OBSERVATION/SUBMISSION TO PLANNING APPLICATION

Case Reference: 324113

Re: Observation to the proposed development of open-cycle gas turbine (OCGT) and generator with ancillary equipment.

Location: Pollnagroagh and Rathmorrissy (Townlands), Athenry, Co. Galway

Purpose		PLANNING			
Title		SITE ACCESS SIGHTLINES			
Original Scale	Design/Drawn	Checked	Authorised		
SHOWN at A1	PS	ND	AJB		
Date	Date	Date	Date		
01.12.25	01.12.25	01.12.25	01.12.25		
Status	Drawing Number	Rev			
A2	PEK3-ATK-ZZ-01-DR-CE-901200	0

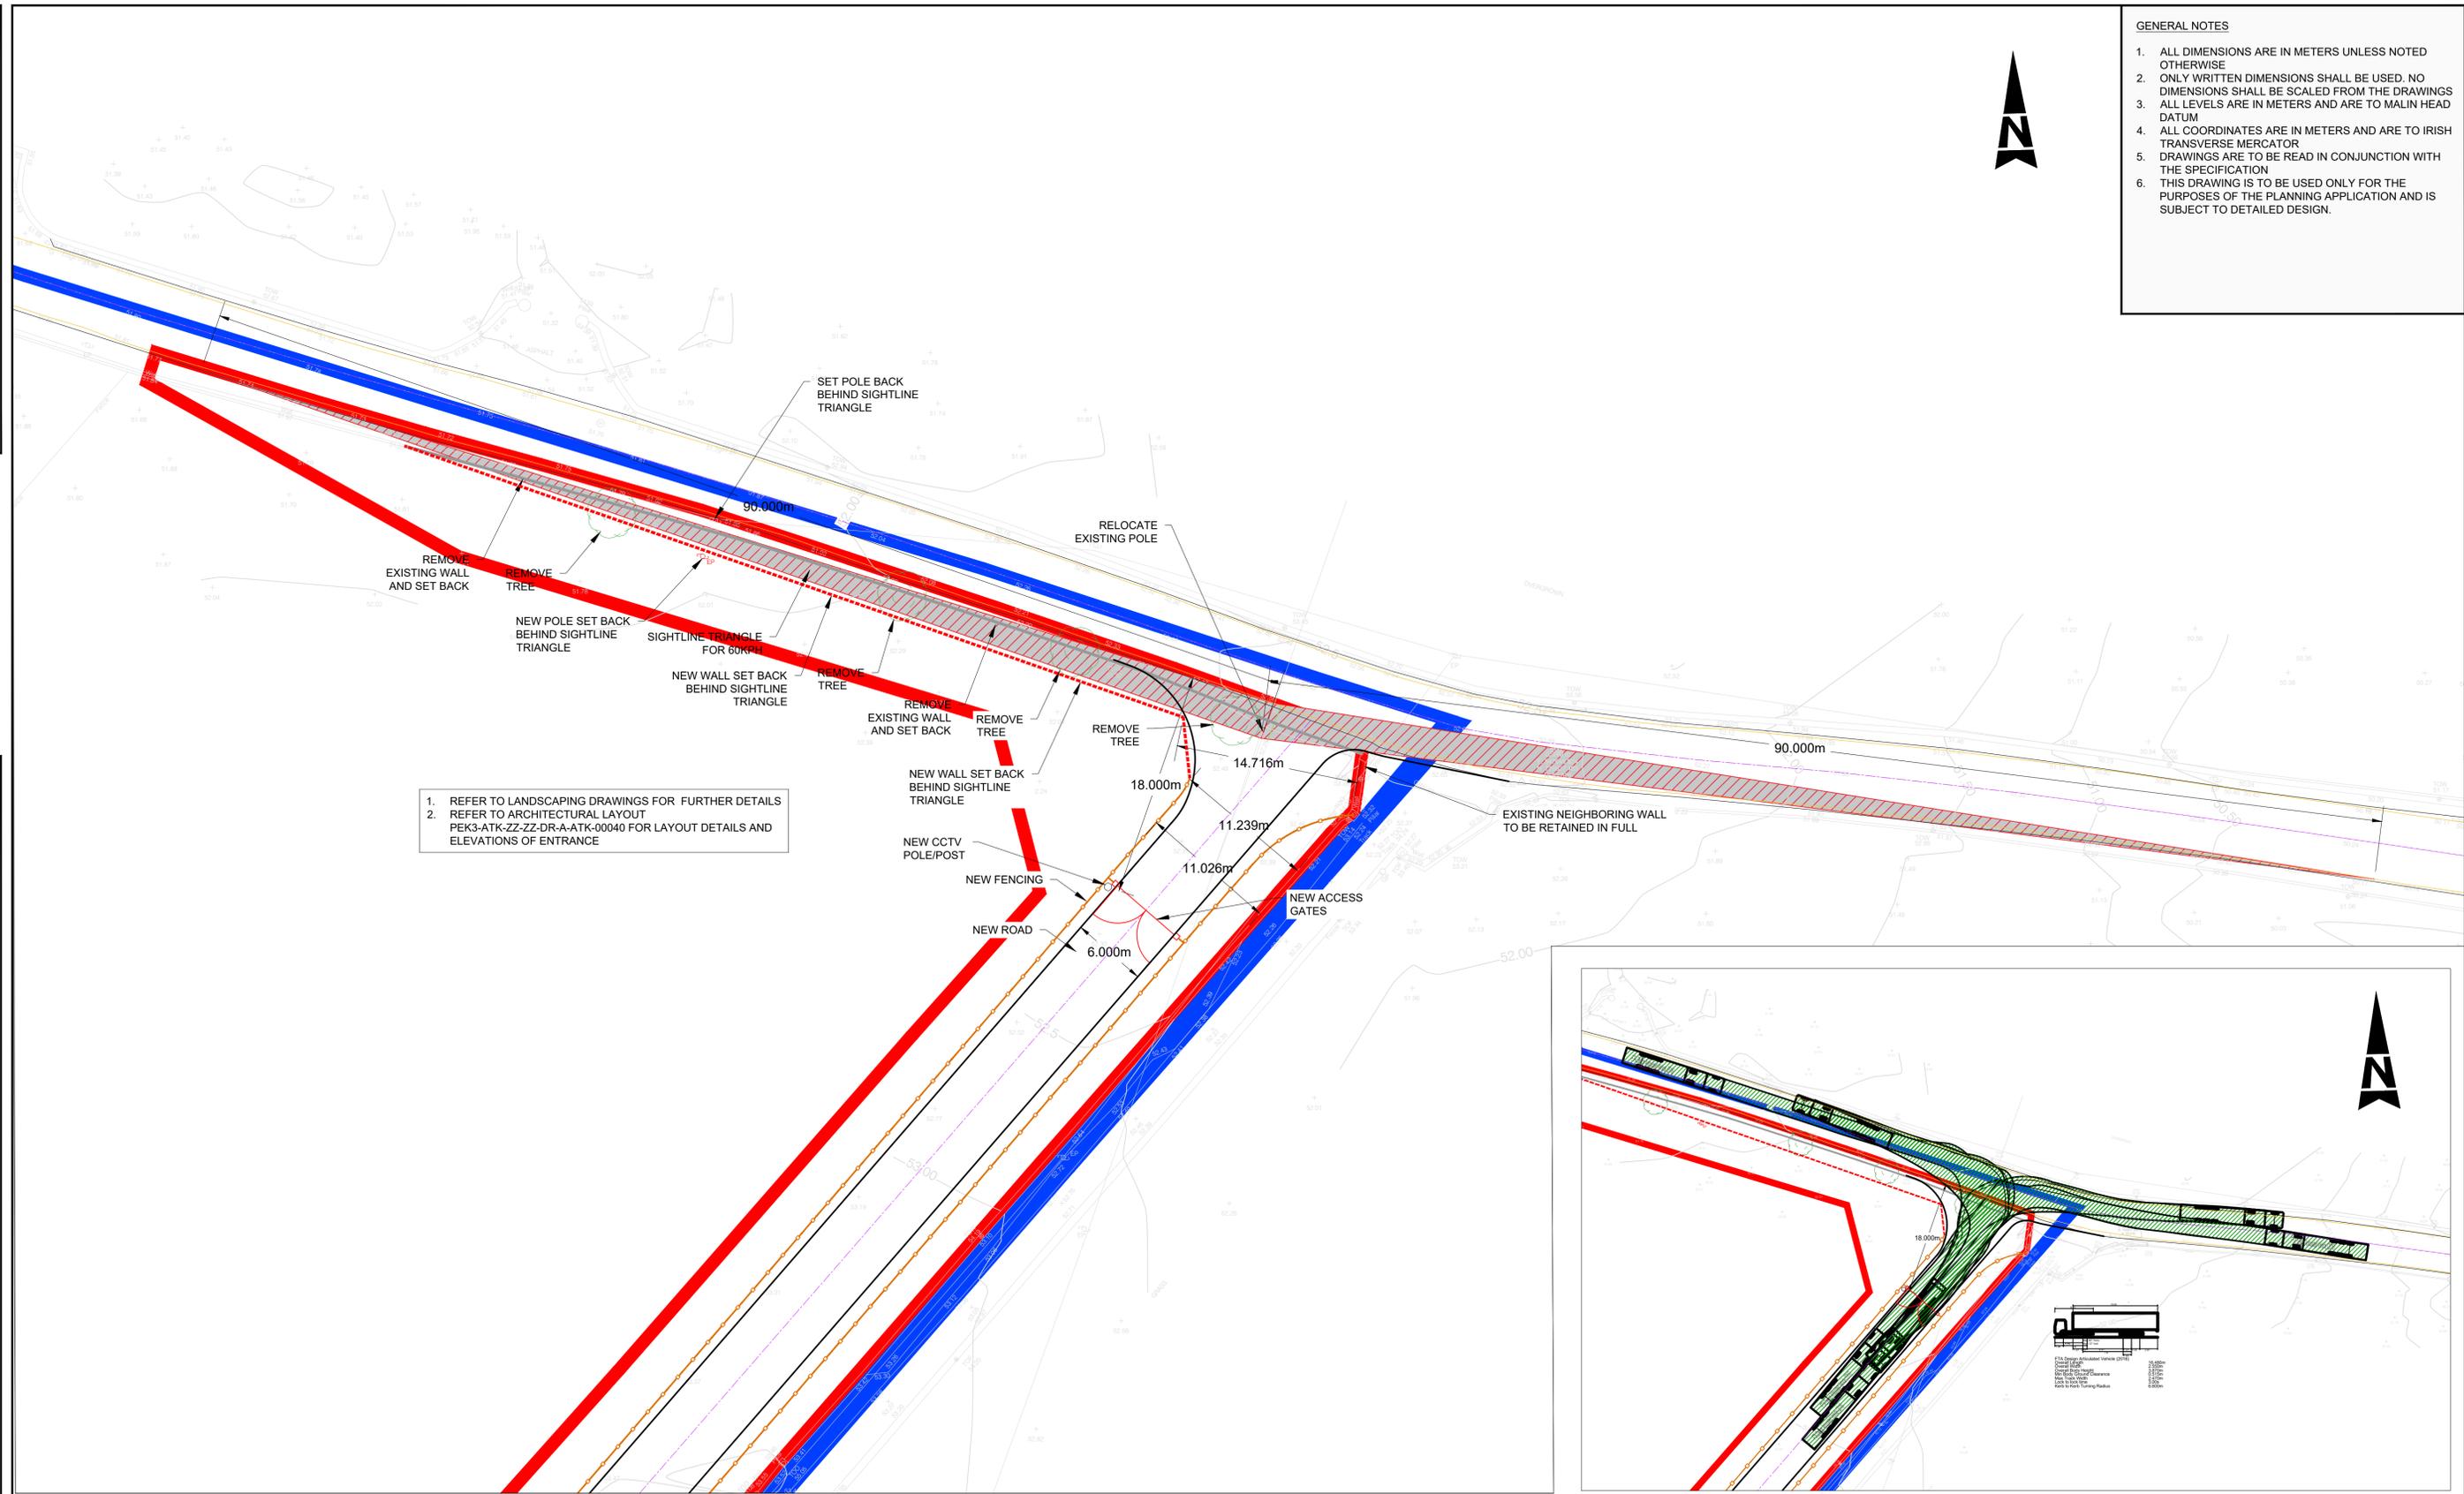
The placement of the proposed site entrance on the L3103 raises severe safety concerns due to the inherently hazardous nature of this specific stretch of road. The carriageway is critically narrow, struggling to safely accommodate two passing Heavy Goods Vehicles (HGVs), and completely lacks a hard shoulder to allow for any margin of error. Compounding these dangers are the presence of blind dips and corners, which significantly reduce visibility and sightlines for all road users. These critical safety deficiencies create an unacceptable traffic hazard that must be comprehensively addressed.

Positioning the site entrance at this location on the L3103 introduces extreme risk to road users. This treacherous section of the road is entirely devoid of a hard shoulder and is physically too narrow for two HGVs to pass one another safely. Furthermore, severely compromised sightlines caused by blind dips and sharp corners make this access point highly perilous. It is imperative that these severe, compounding traffic hazards are urgently mitigated before any development is permitted.

The proposed site entrance is located on an exceptionally dangerous section of the L3103. Establishing an access point at this specific location introduces an unacceptable level of risk due to several compounding hazards:

- **Severely Restricted Width:** The road is currently too narrow to safely permit two Heavy Goods Vehicles to pass simultaneously.
- **Absence of a Hard Shoulder:** There is no safe refuge or margin for error for manoeuvring vehicles.
- **Critically Poor Visibility:** The immediate area is affected by blind dips and blind corners, severely compromising driver sightlines.

The placement of a site entrance at this hazardous location on the L3103 introduces significant and clearly identifiable safety risks, including restricted road width, lack of a hard shoulder, and severely limited visibility

due to blind dips and corners. Despite these known constraints, the Environmental Impact Assessment does not adequately assess the safety implications of this access point.
